BOCA[®]
NATIONAL BUILDING CODE/1999
PLAN REVIEW RECORD

Valuation: To Be Determined Plan Review # 040331
 Fee: Determined Date: 04/15/04

BUILDING LOCATION 85 CENTRAL AVE PEARS DS.

BUILDING DESCRIPTION 12388 SQ FT. 12-RESIDENTIAL UNITS +
Attch'd Building - Wood Frame.

1 ROOF PLAN
SCALE 1/8" = 1'-0"

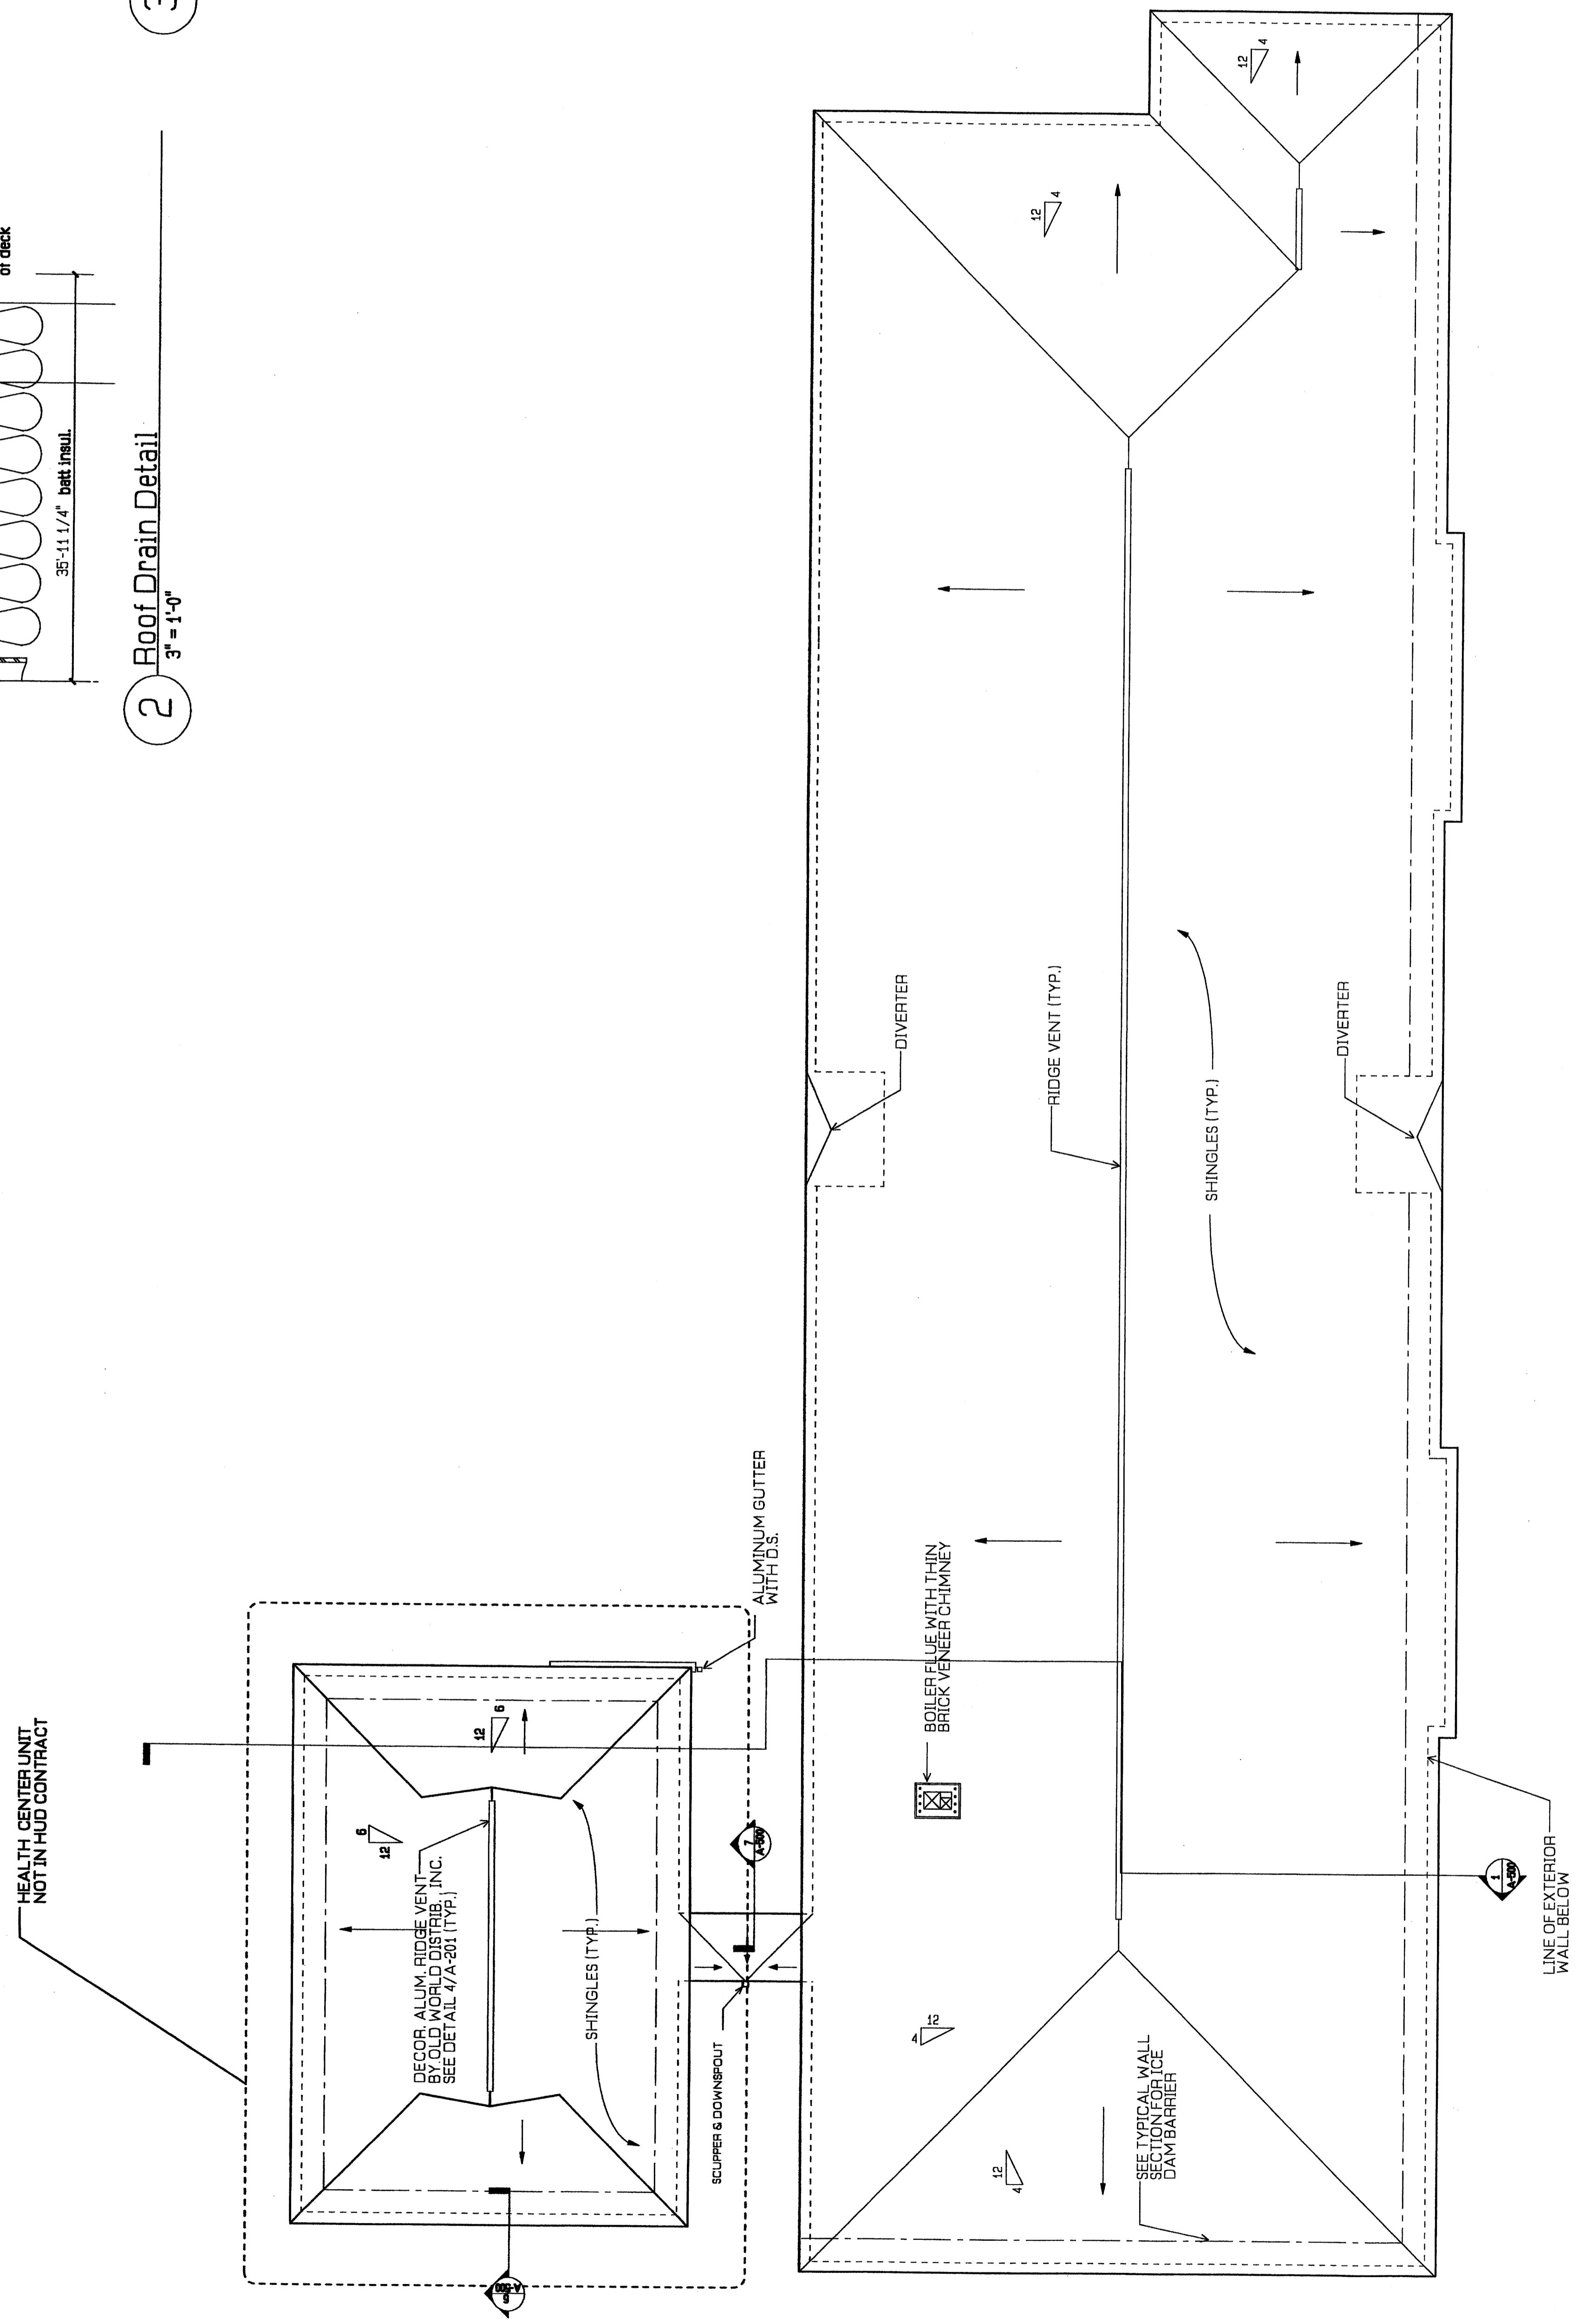
CORRECTION LIST			Code Section
No.	DESCRIPTION		
1	NEED GEOTECHNICAL REPORT		1804
2	USE GROUPS - MIXED USE? SEPARATED OR NON SEPARATED?		
3	ON PAGE 201-2 BUT BEARING WALLS PAGE 203		
4	AWAY FROM AN OFFICE WINDOWS RATED
